From: [Public Health Inspectors](#)
To: [Chace Pedersen](#)
Subject: RE: SP-23-00004 Singer - Notice of Application
Date: Wednesday, July 19, 2023 11:42:33 AM
Attachments: [Singer.docx](#)
[image001.png](#)

Subdivision Comments

To: Chace Pedersen, Planner I
From: Kim Shilley, Public Health Technician
Date: 7/19/2023
RE: SP-23-00004 Singer

## SINGER SHORT PLAT PART OF SECTION 5, T. 17 N., R. 19 E., W.M. KITTITAS COUNTY, WA

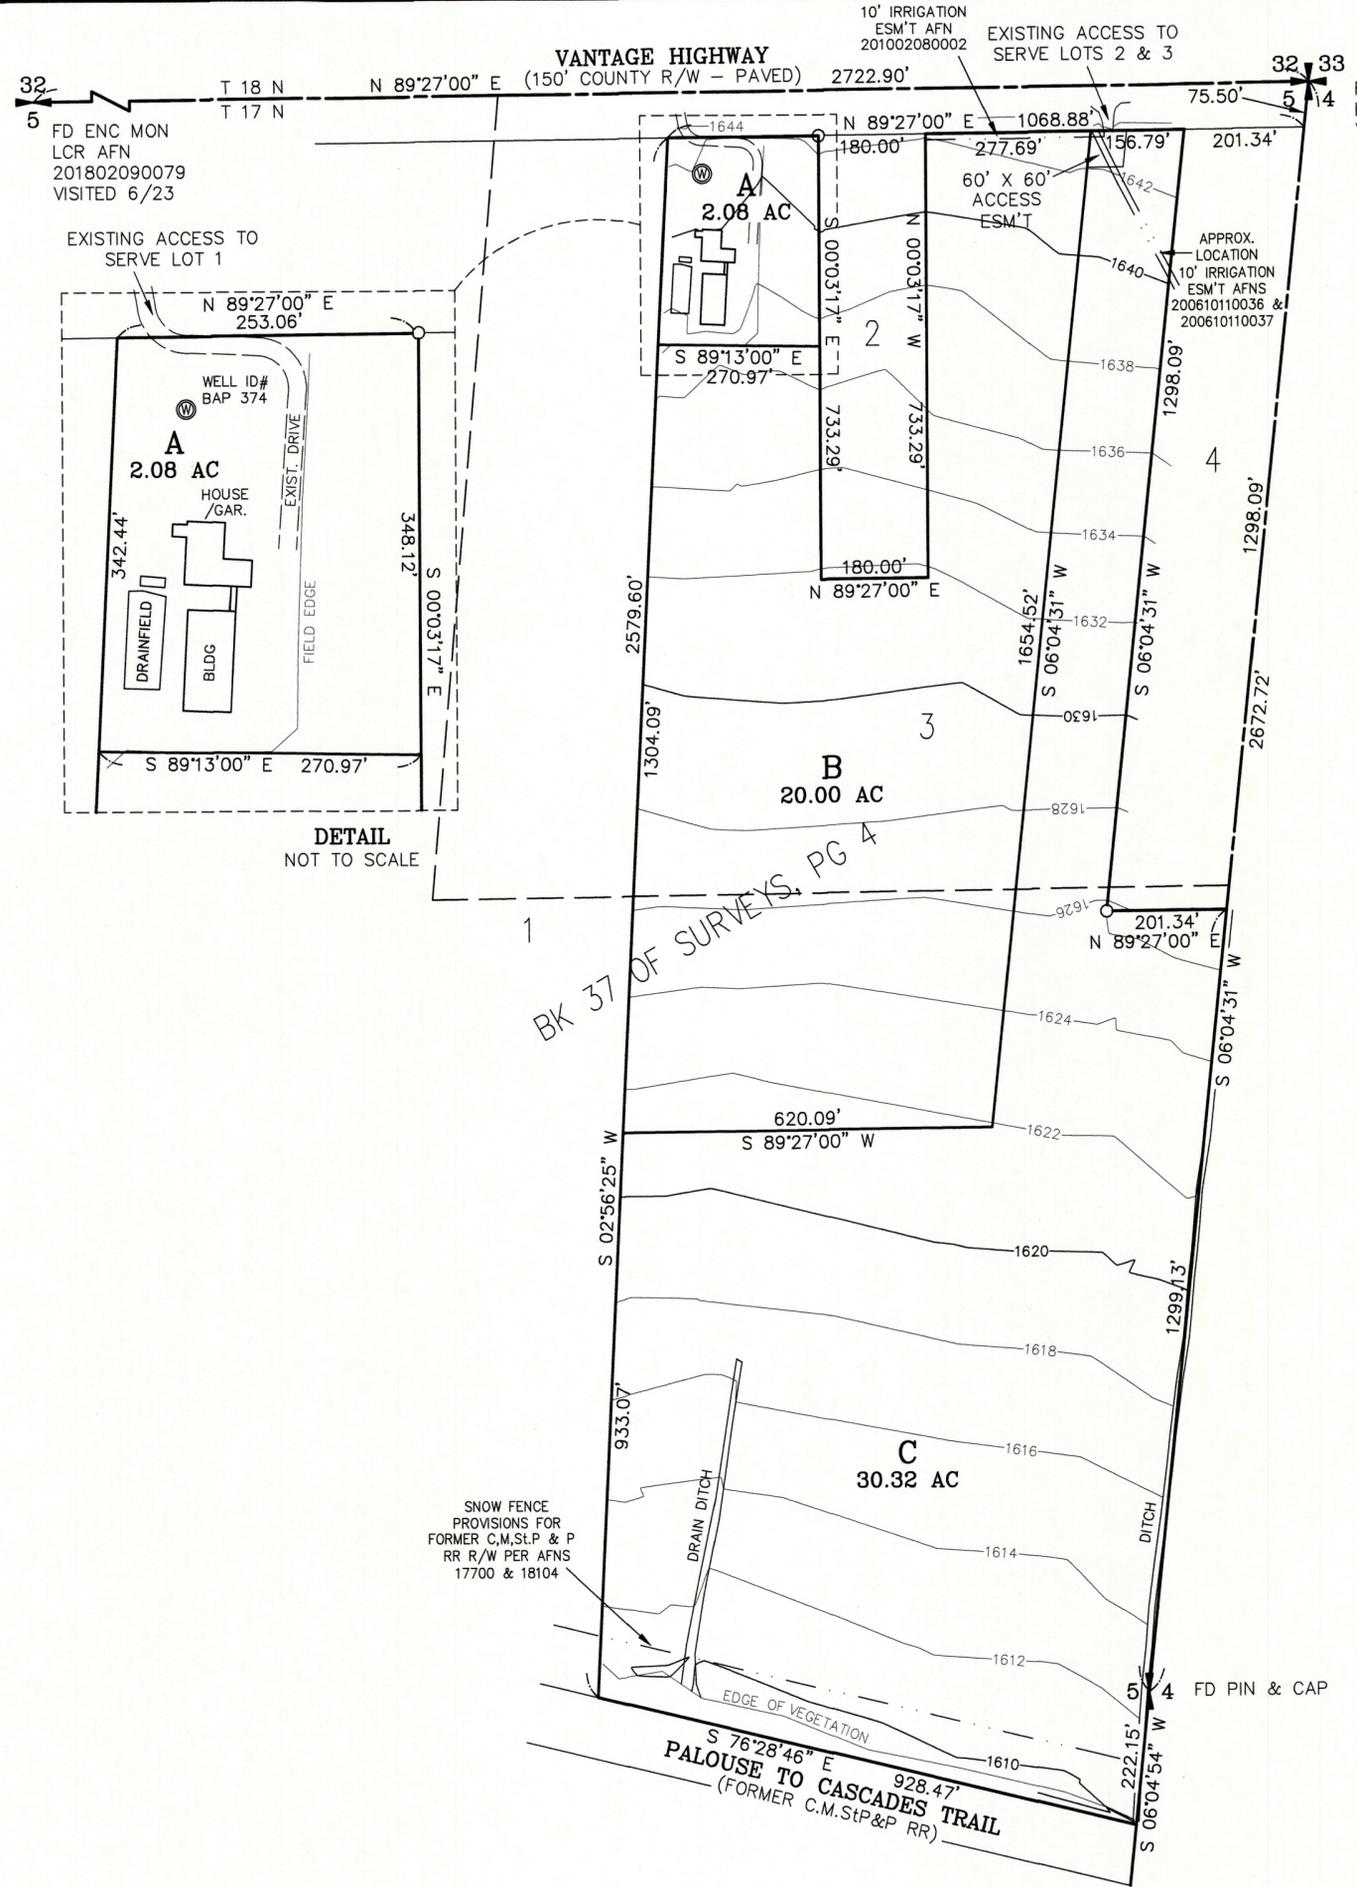
Proposed short plat indicates shared wells will be used. If shared wells are to be utilized, the wells must be drilled a minimum of 50 feet from any proposed property line and a signed, notarized and recorded shared waters users' agreement for each shared well must be submitted to our office prior to final plat approval. The applicant must prove physical availability of water for all new uses of water proposed lots of this project, which can be provided by (See Condition A-1) a well log or 4 hour draw down test as proof of water availability for each new well proposed. All persons who are making applications for land use including but not limited to short plats must comply with KCC Chapter 13.35.020.

A signed and recorded shared water user's agreement between proposed lots is needed. Along with a current water right for the proposed lots.

A-1 13.35.020(b) requires proof of adequate water supply, which can be submitted through a well log or 4 -hour draw down test if an existing well is used and is older than 10 years. If shared wells are used, a signed, notarized, and recorded shared well=users agreement must be submitted. All individual and shared wells must meet the distance requirement of 50 feet from the property line, 50 feet from the septic tank and 100 feet from the drain field as per Kittitas County Critical Areas Ordinance 17A.08.25, and KCC Chapter 13.
